**Subject:** RE: Hambledon View  
**From:** Younas, Mohammed (Mohammed.Younas@uuplc.co.uk)  
**To:** frank\_unsworth@yahoo.co.uk;  
**Date:** Wednesday, 15 March 2017, 15:43

Drawing No.
DWG/04/Plot 3

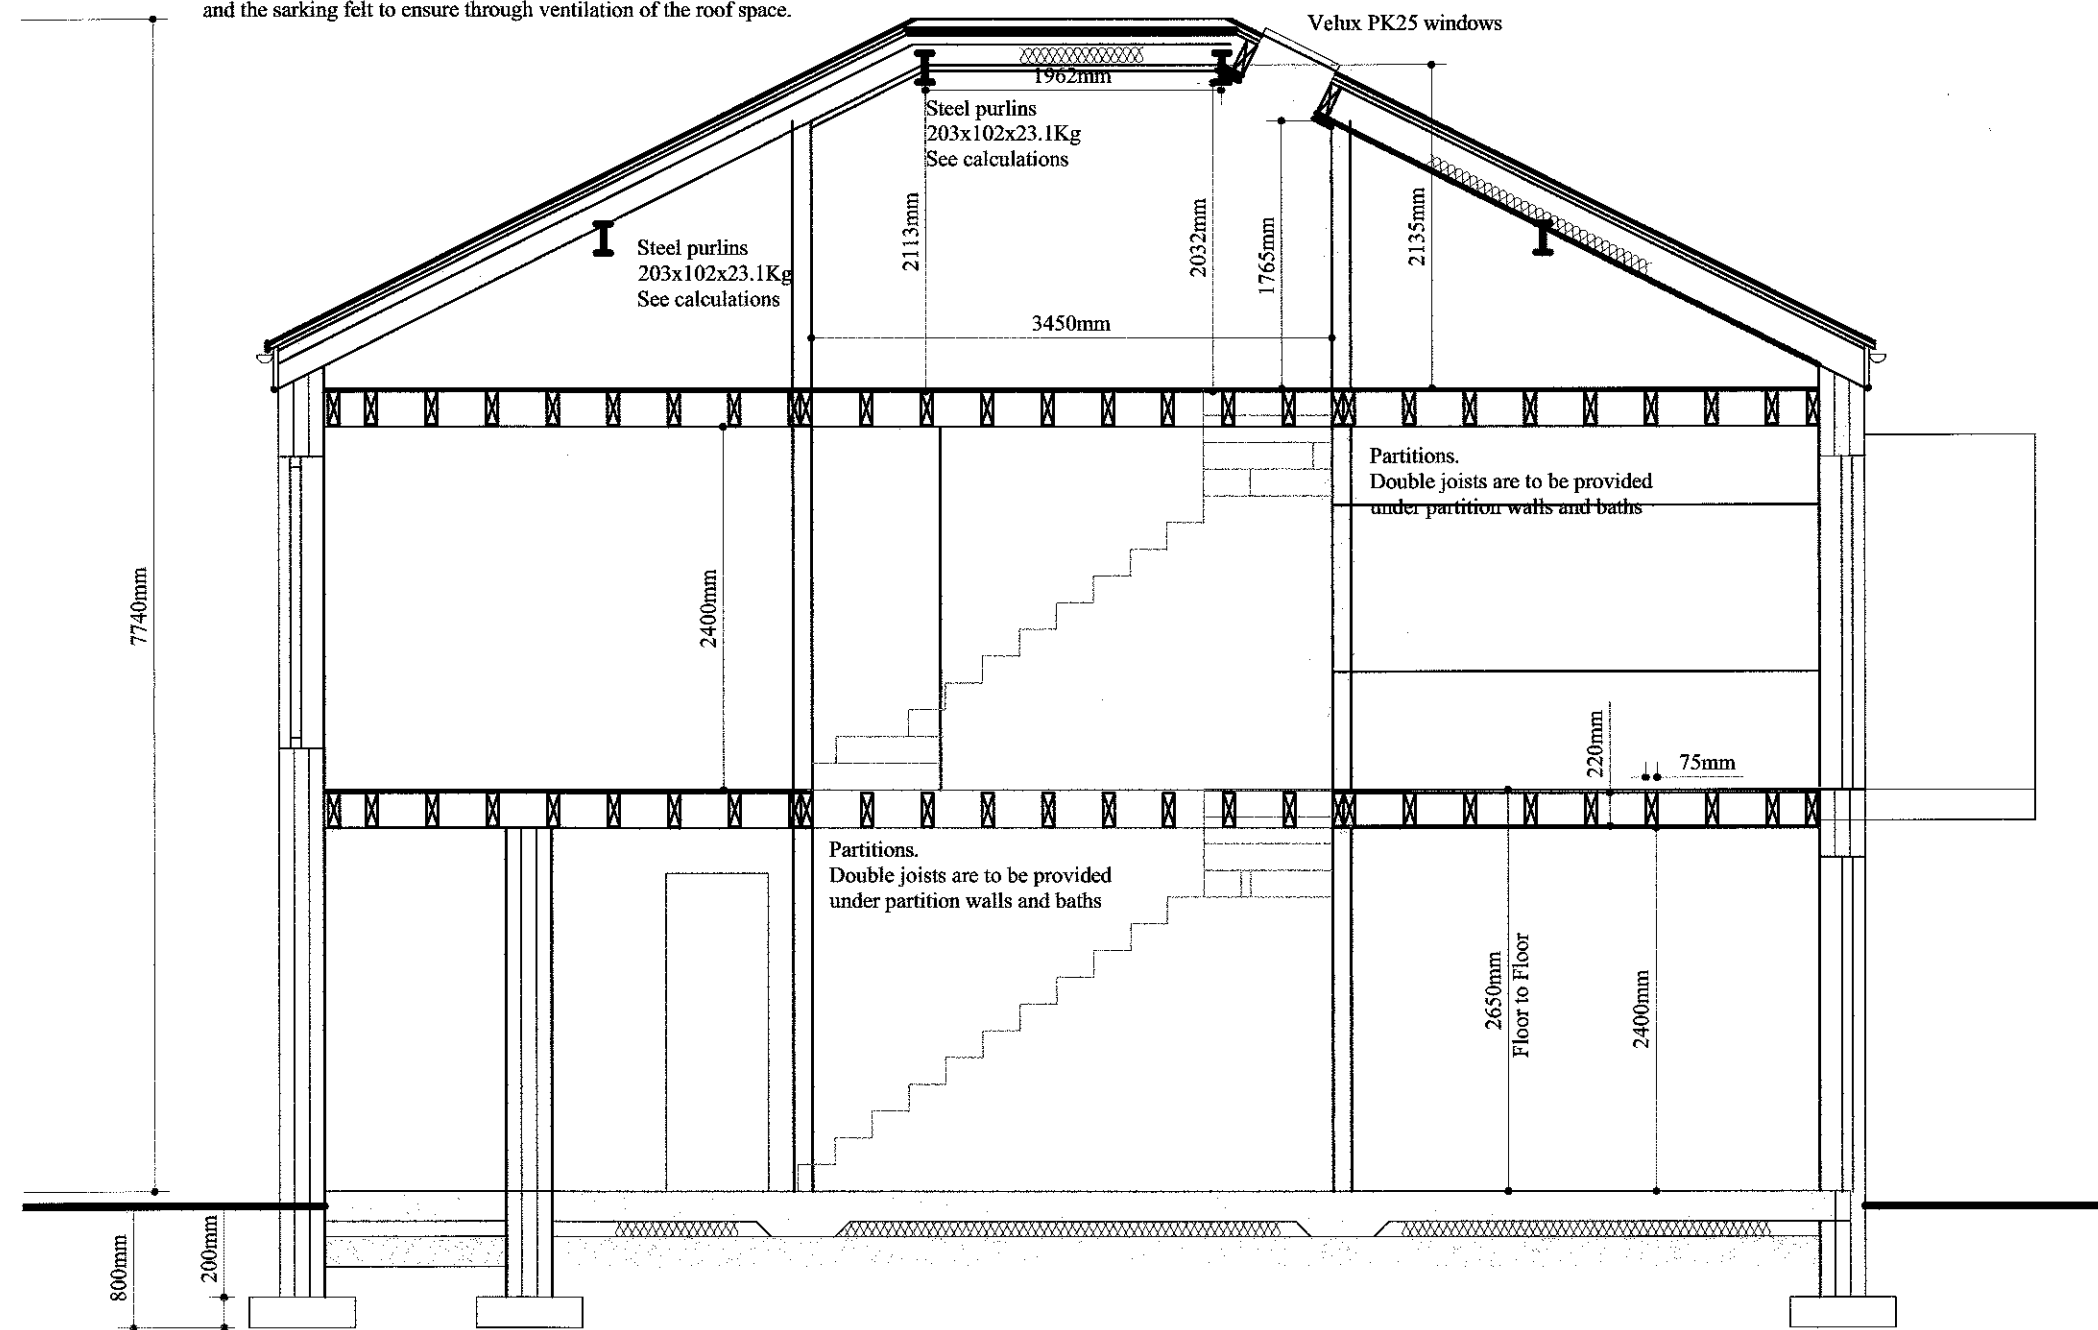
I will have no objection to the proposed development provided Part H4 of building Regulation is satisfied.

Redundant drains/sewer running under the development would require either grubbing out or filling with concrete.

No formal building over agreement is required in this instance.
